From: Planning
Sent: 03 October 2022 14:20
To: DC Support
Subject: FW: 22/01682/F - Land North Of Manor Farm Noke

Land North Of Manor Farm, Noke.

Development of a ground mounted solar farm incorporating the installation of solar PV panels, associated infrastructure and access, as well as landscape planting and designated ecological enhancement areas.

IMPLEMENTATION AND MAINTENANCE GUIDELINES

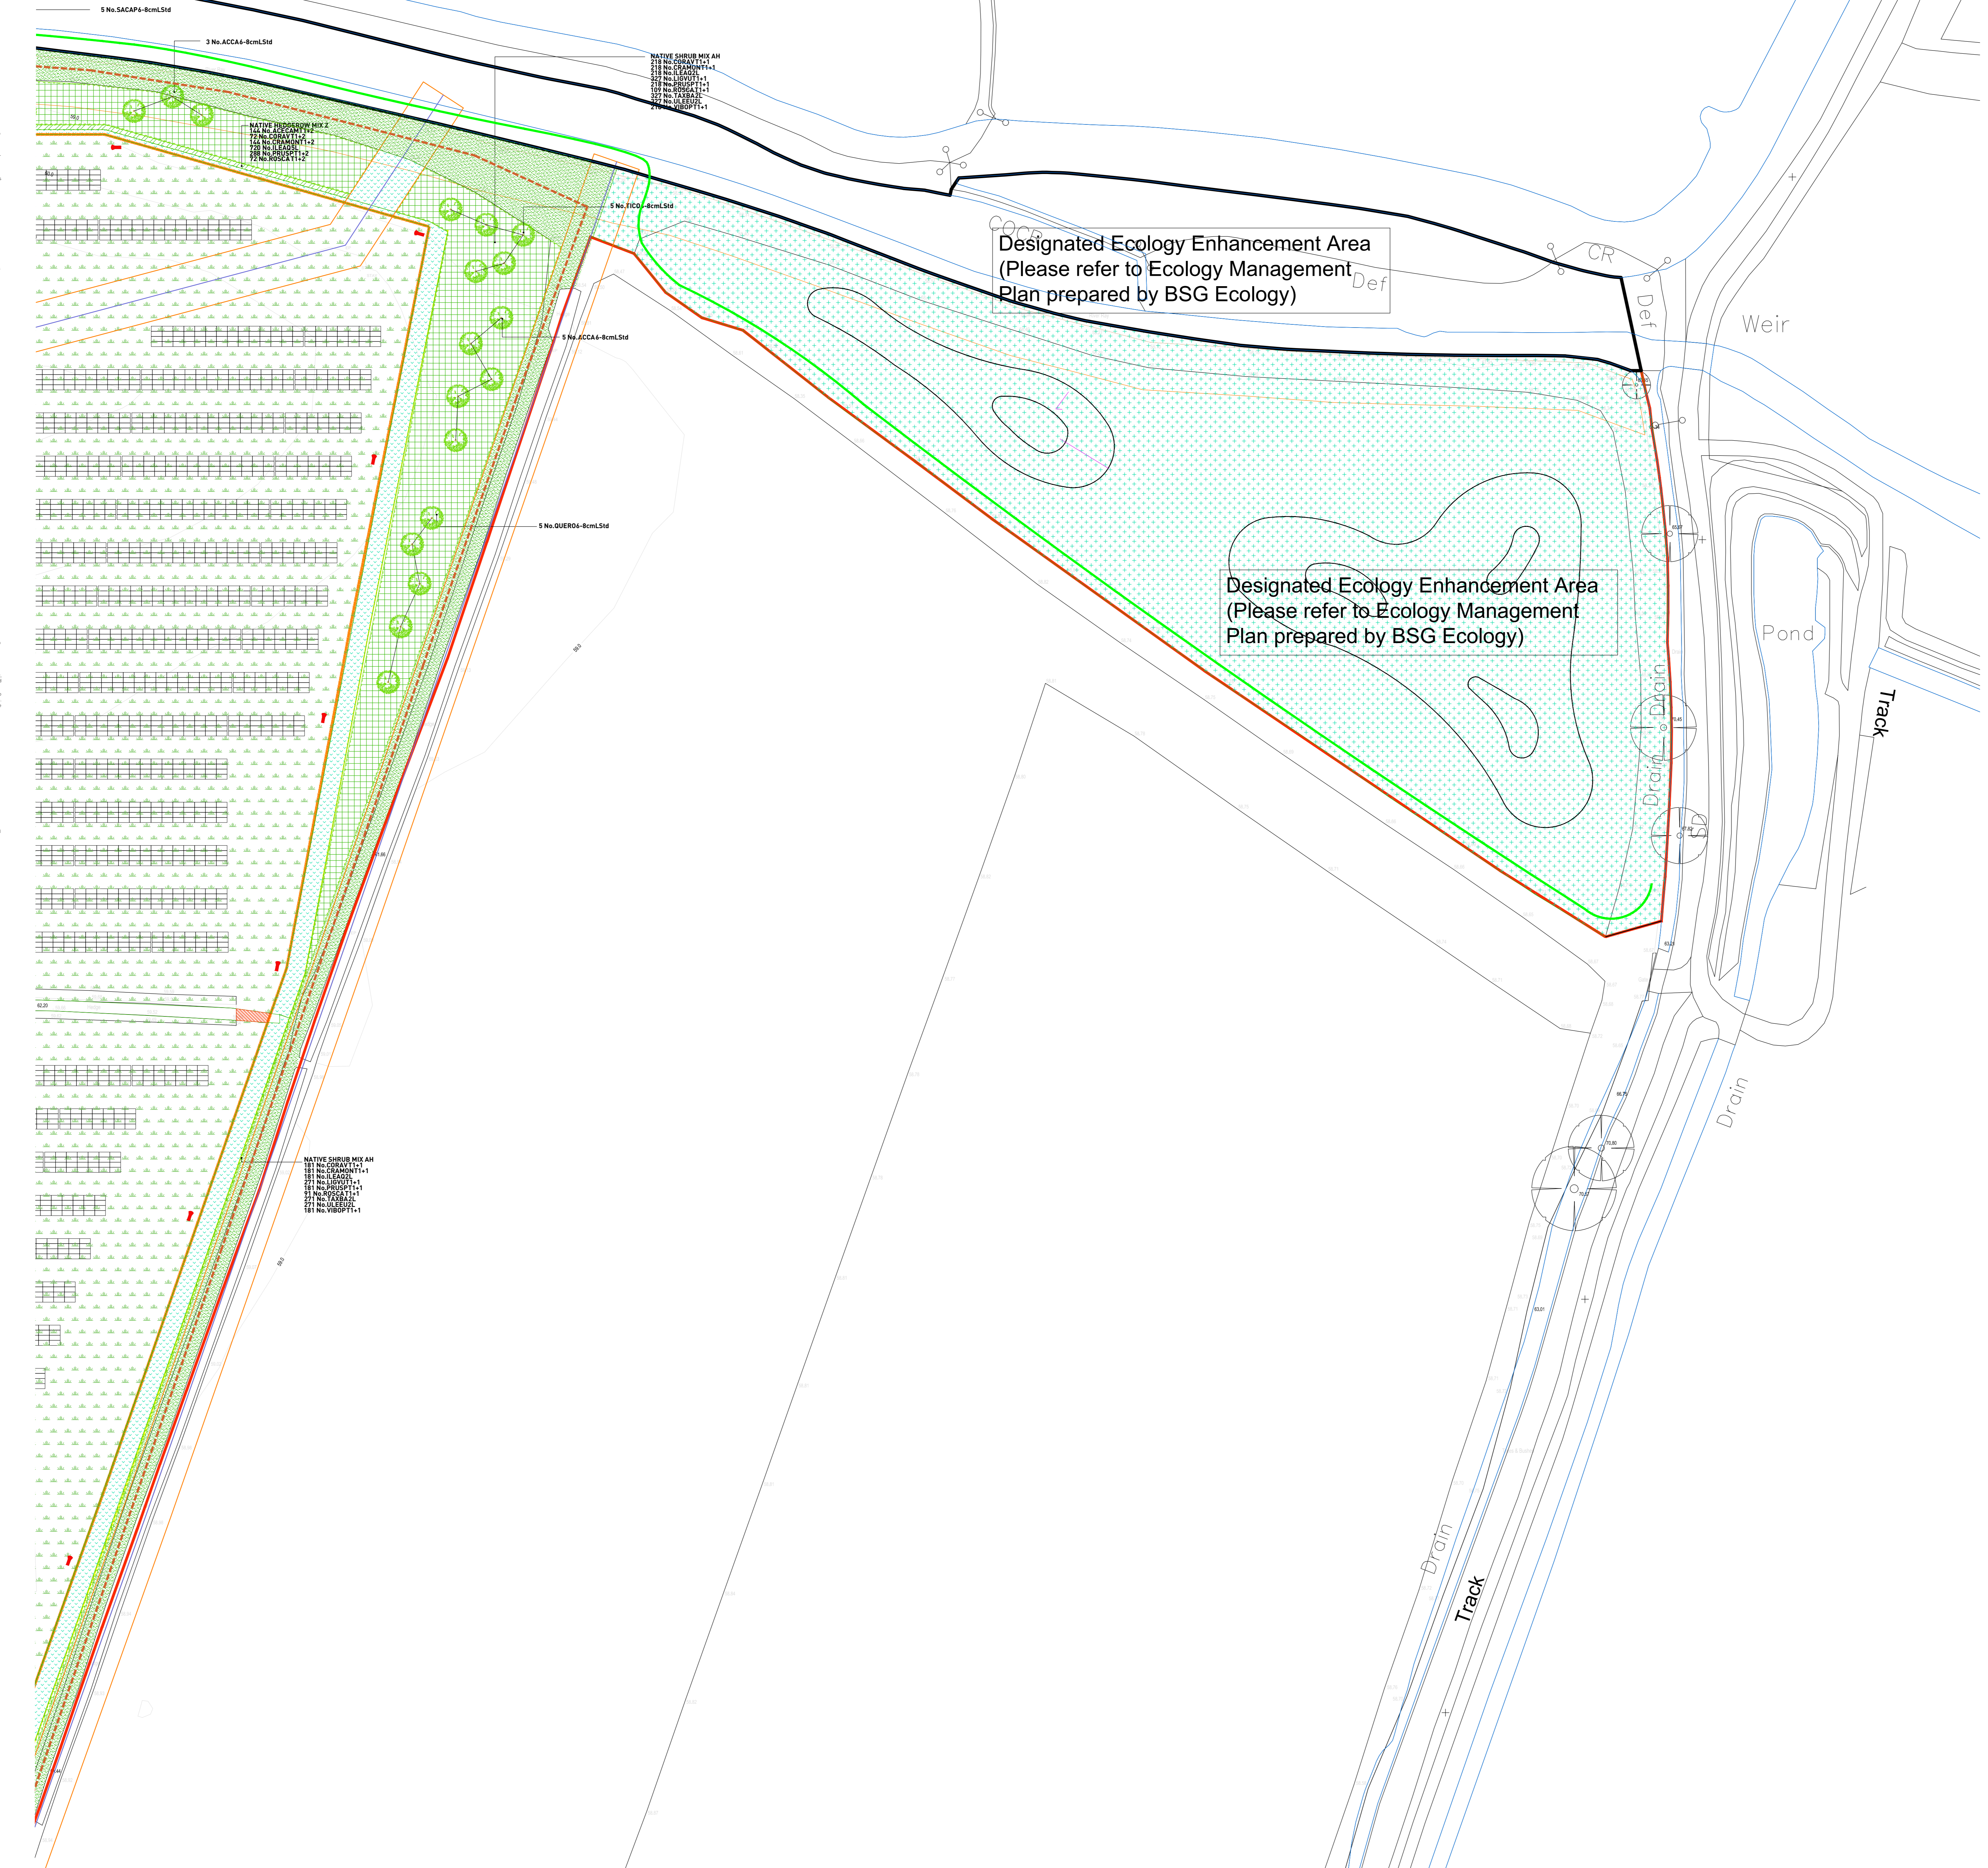
Although the landscape masterplan is favourably comprehensive and offers a good level of detail (as shown in the supporting Soft Landscape Proposals sheets 1-7) in providing a screening by the 15th year of completion it would undoubtedly reduce the openness of the Green Belt and constitute encroachment into the countryside, causing significant harm. The application meets a number of the 'very special circumstances' for the need for renewable energy, however the size and magnitude of the application and the visual impact on the Green Belt is still seen as being inappropriate.
